Charlotte Department of Transportation

Memorandum

Subject: Rezoning Petition 08-035: Located on both sides of Statesville Avenue between Woodward Avenue and Dearborn Avenue (revised 12/20/07)

SP101

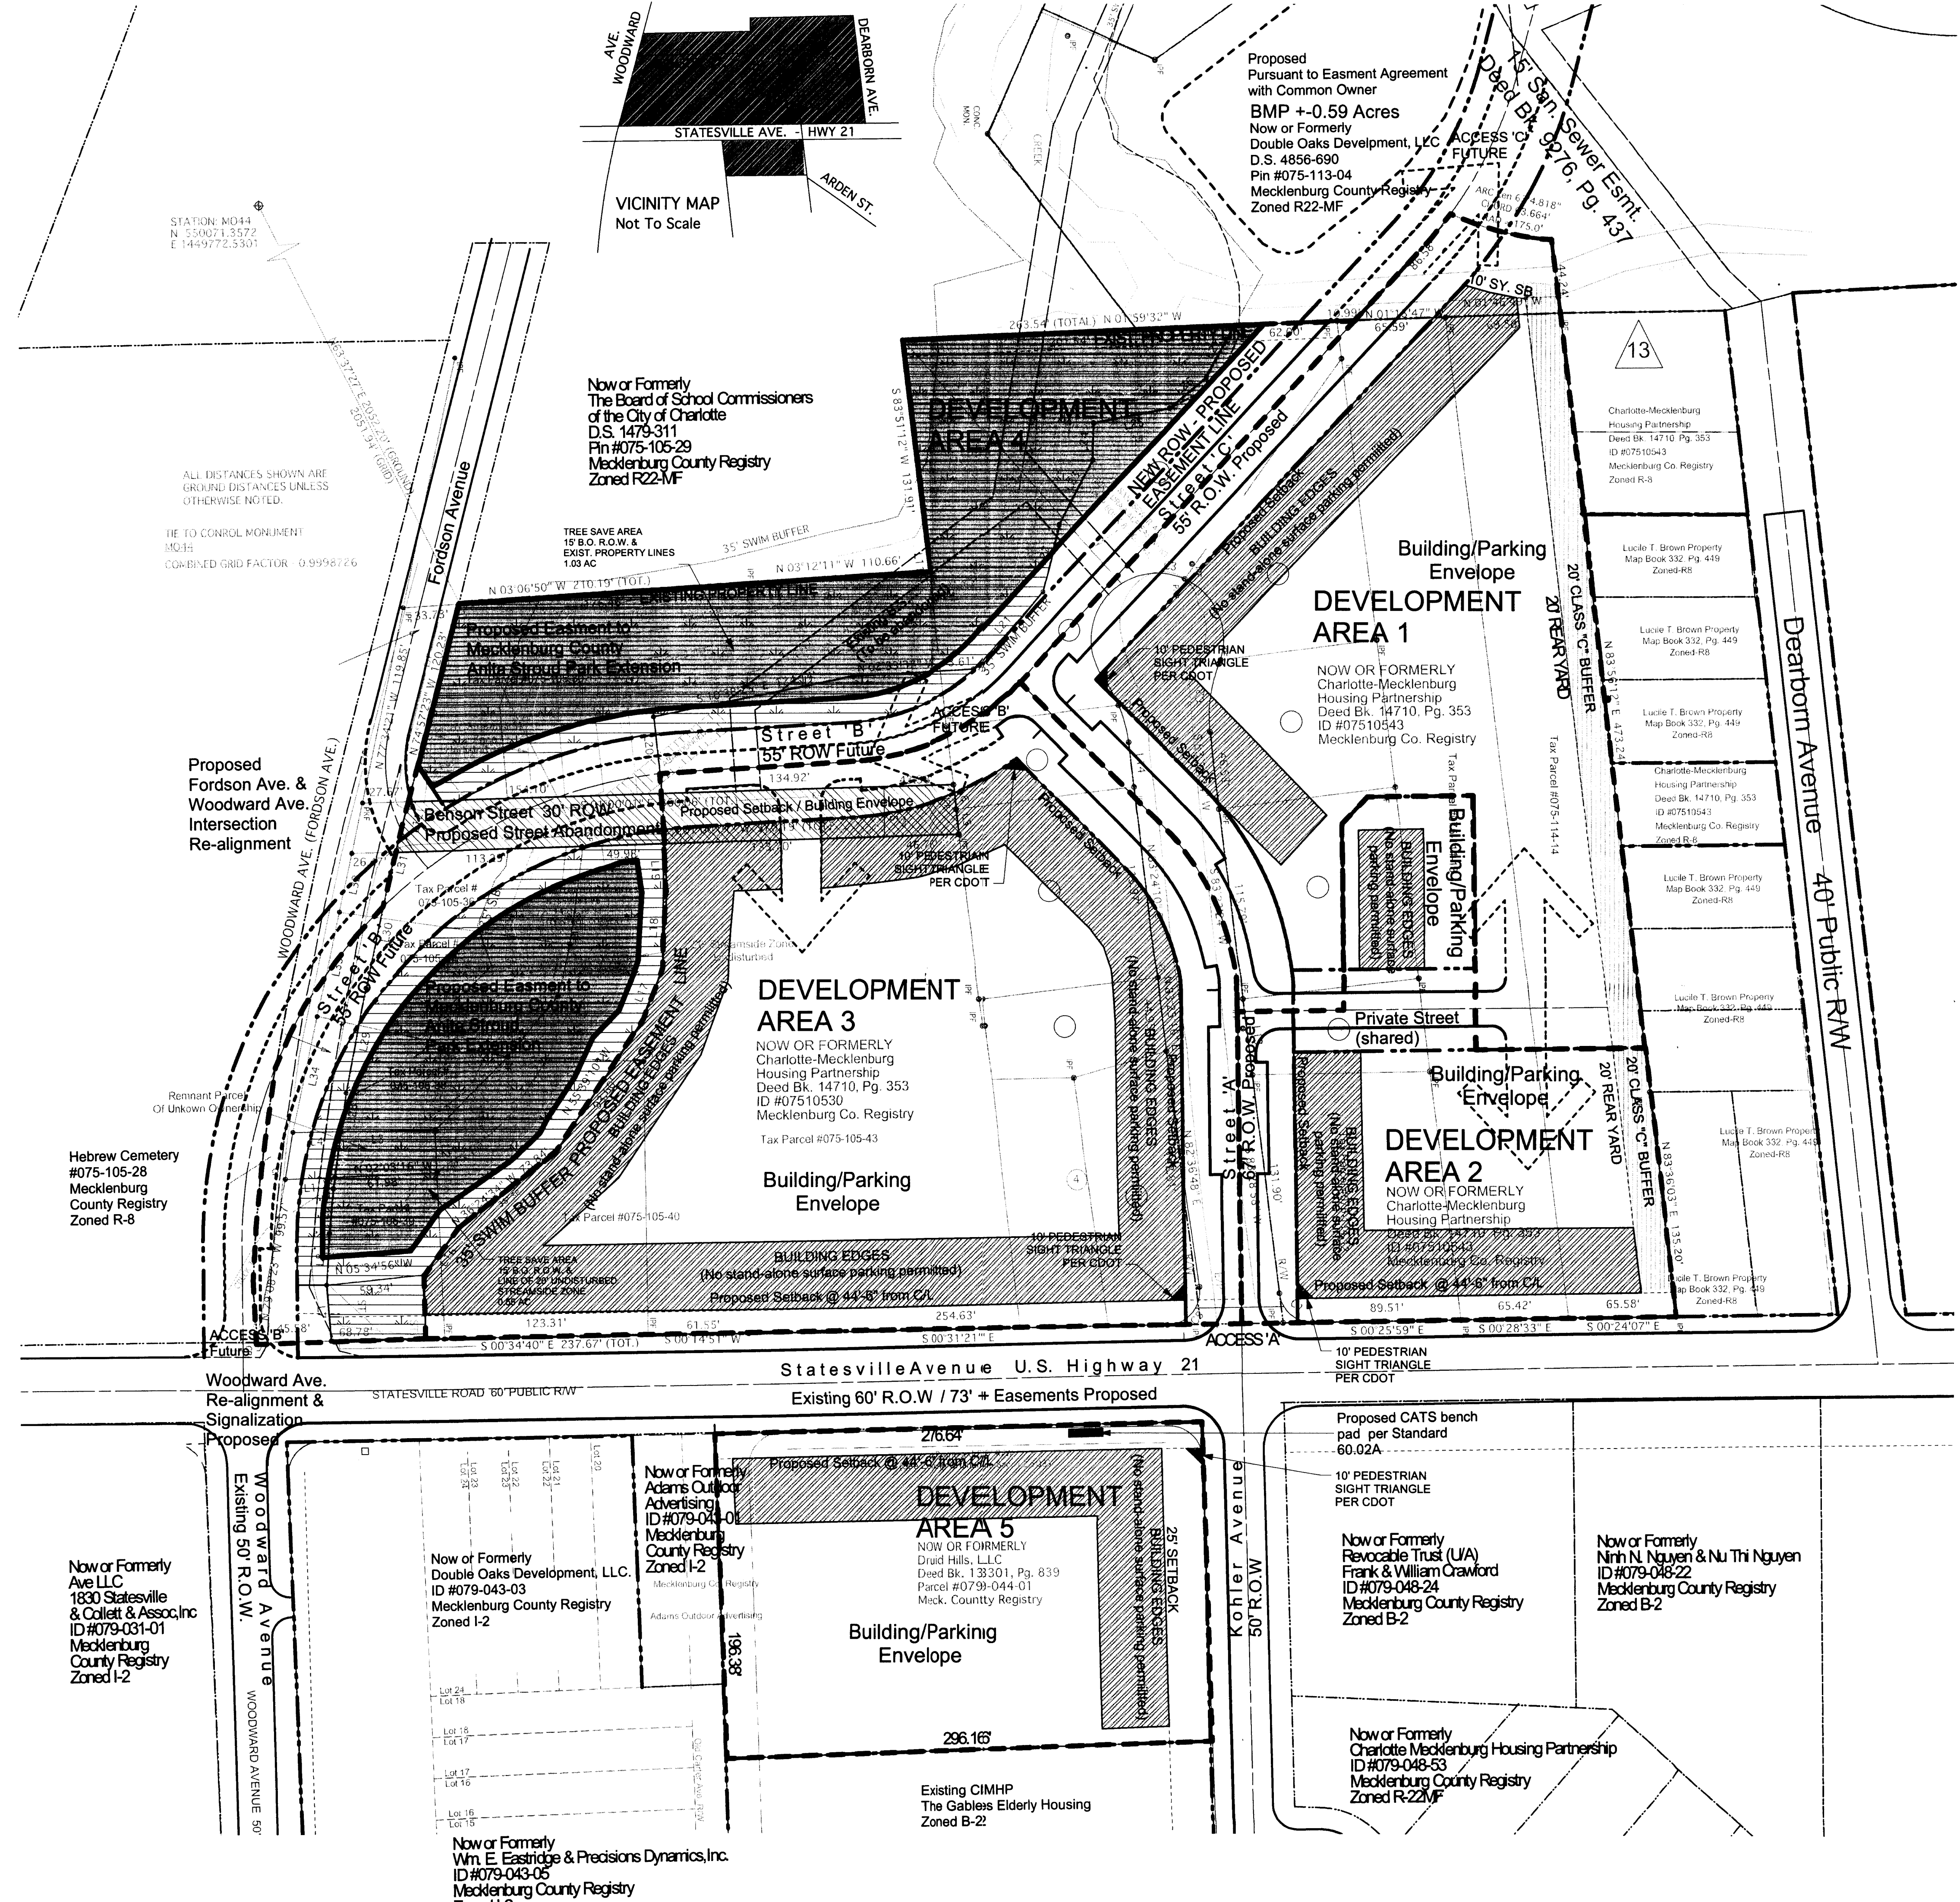
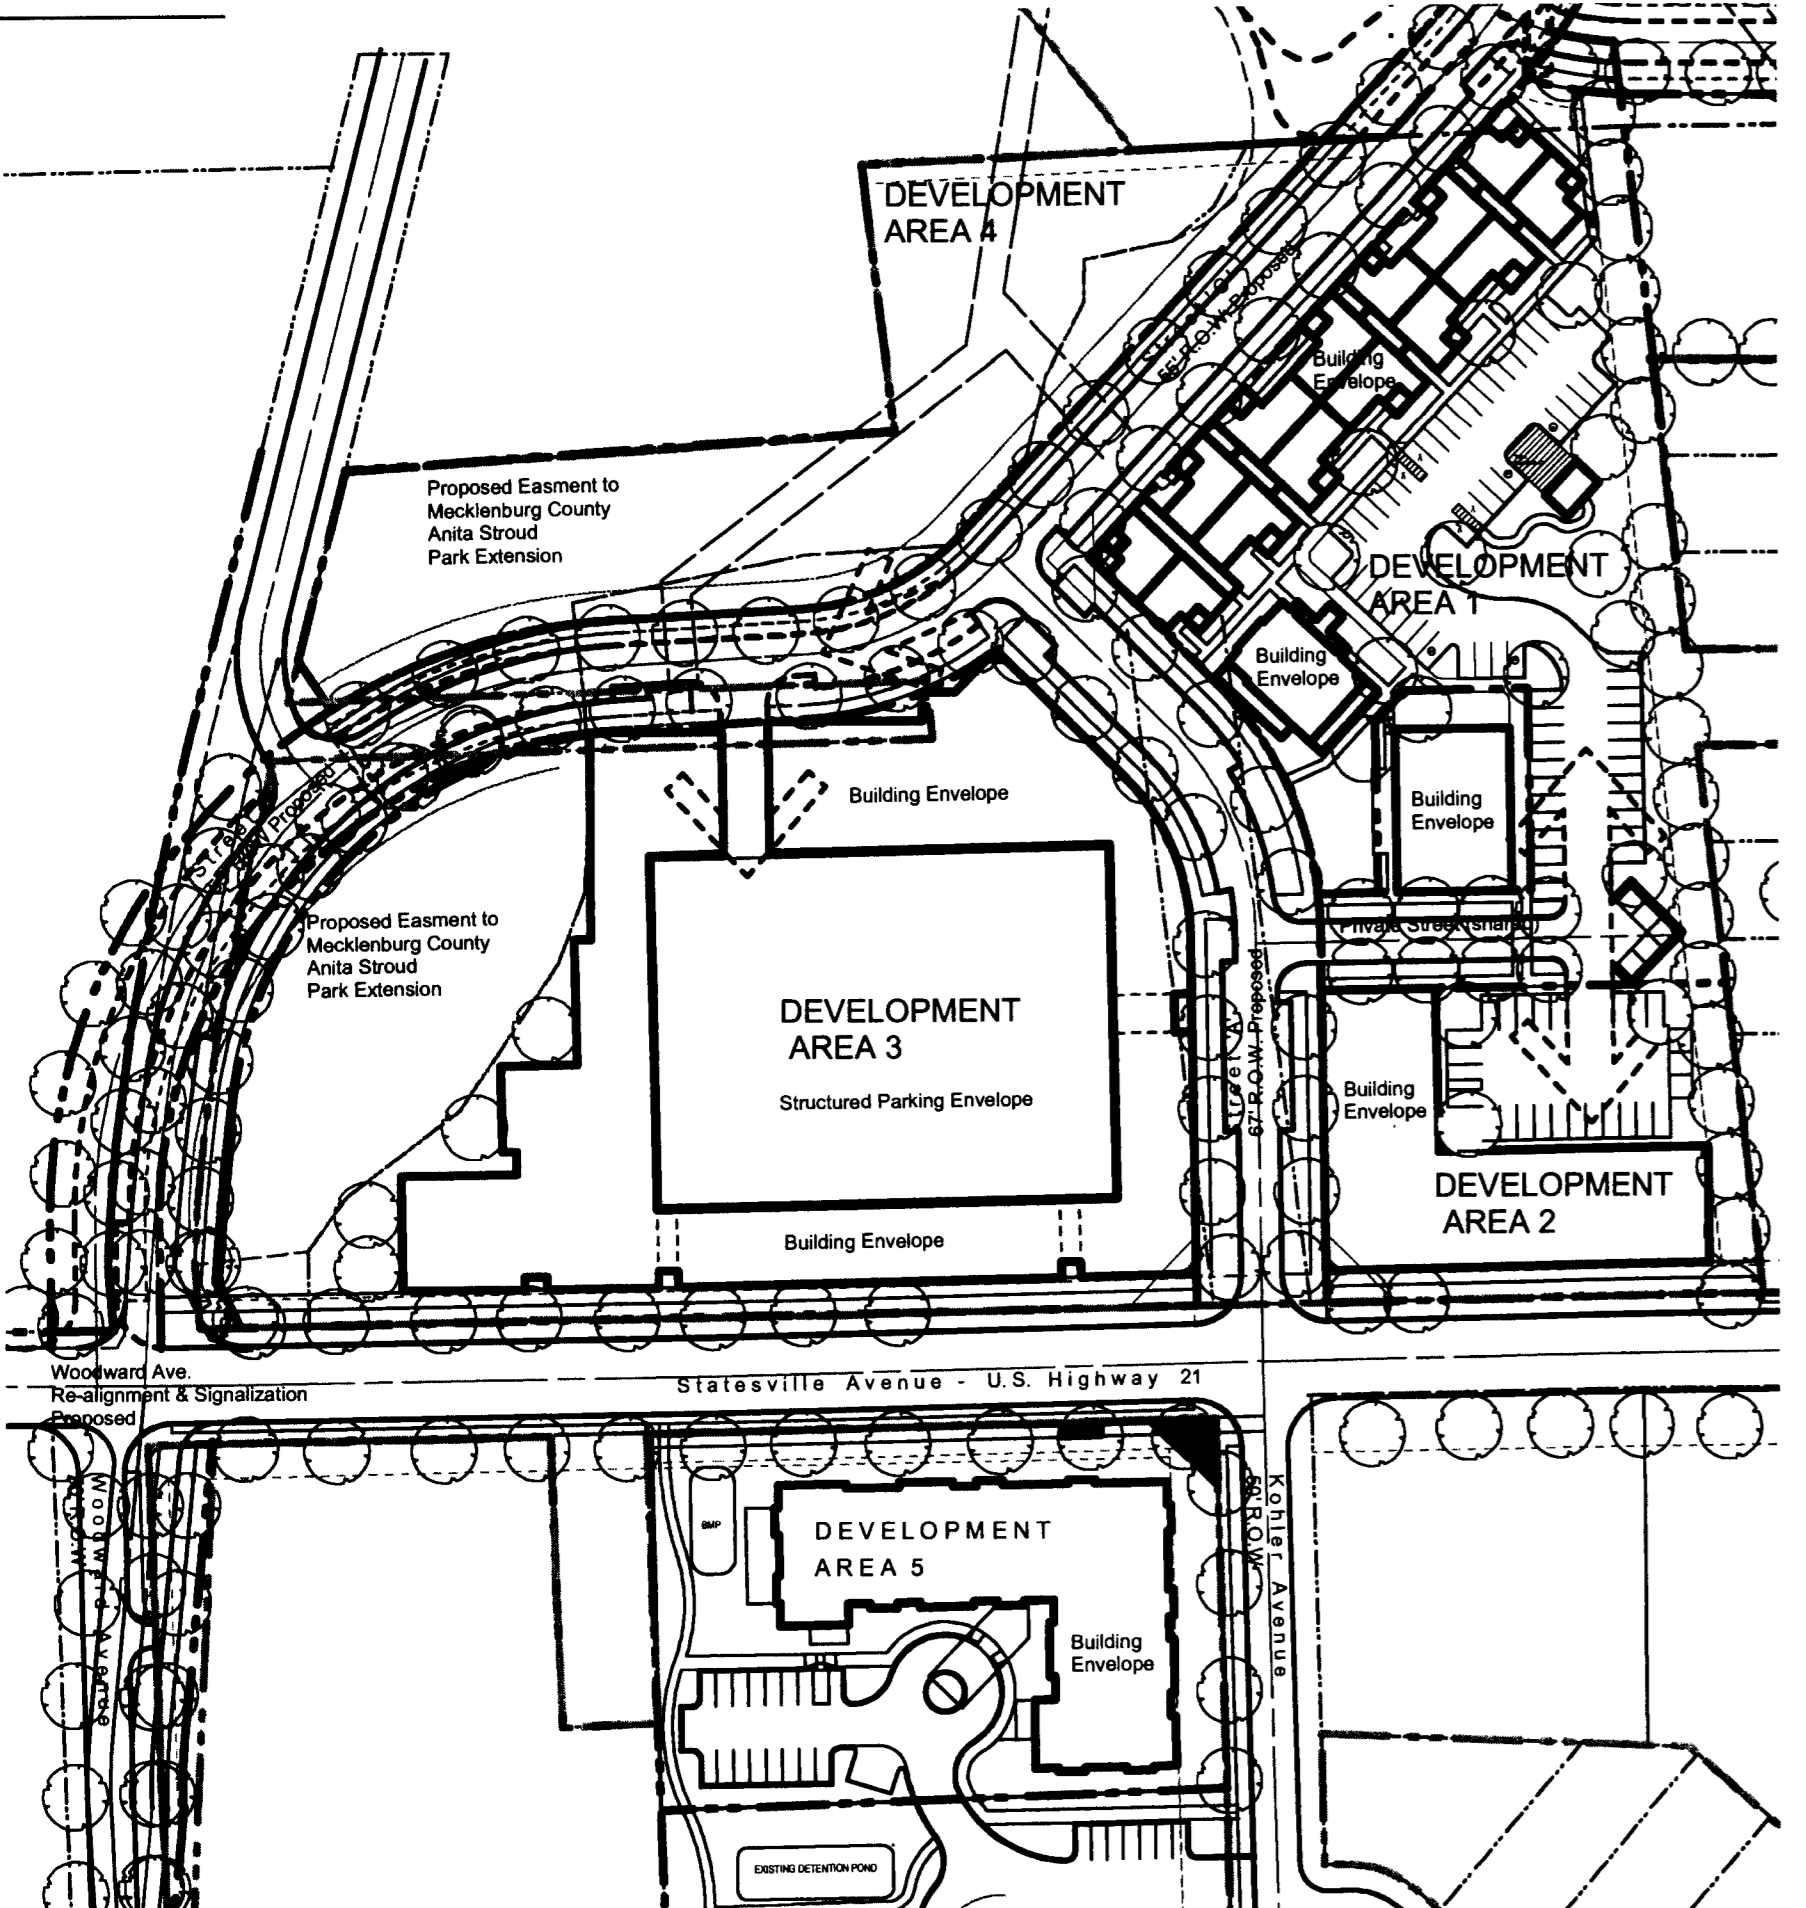
1. The site plan shows a proposed realignment of Fordson/Woodward Avenues to directly connect as the 4th leg of the existing Statesville/Woodward intersection. This proposed realignment and necessary improvements will be further reviewed by CDOT and the NCDOT during the review of the TIS. *(Previous review comment)*

2. The proposed realignment of Woodward Avenue is shown on an adjacent parcel (075-105-28). This property needs to be acquired before the realignment can be approved and noted on the site plan. *(Previous review comment)*

3. Development Area 1 on the plan shows a future connection to a future or existing street. This connection is too close to the intersection of proposed Woodward Avenue and this street and needs to be removed from the plan. *(Previous review comment)*

4. The proposed realignment of Woodward Avenue directly affects the access to an adjacent elementary school. The petitioner needs to demonstrate that the realignment will not adversely affect stacking for student pick up at the school. The petitioner needs to have discussions with the school/CMS and accommodate the needs of the school with their roadway design. *(Previous review comment)*

1. New streets need to be designed as Medium Local Residential Streets in accordance with the Urban Street Design Guidelines (USDG). *(Previous review comment)*
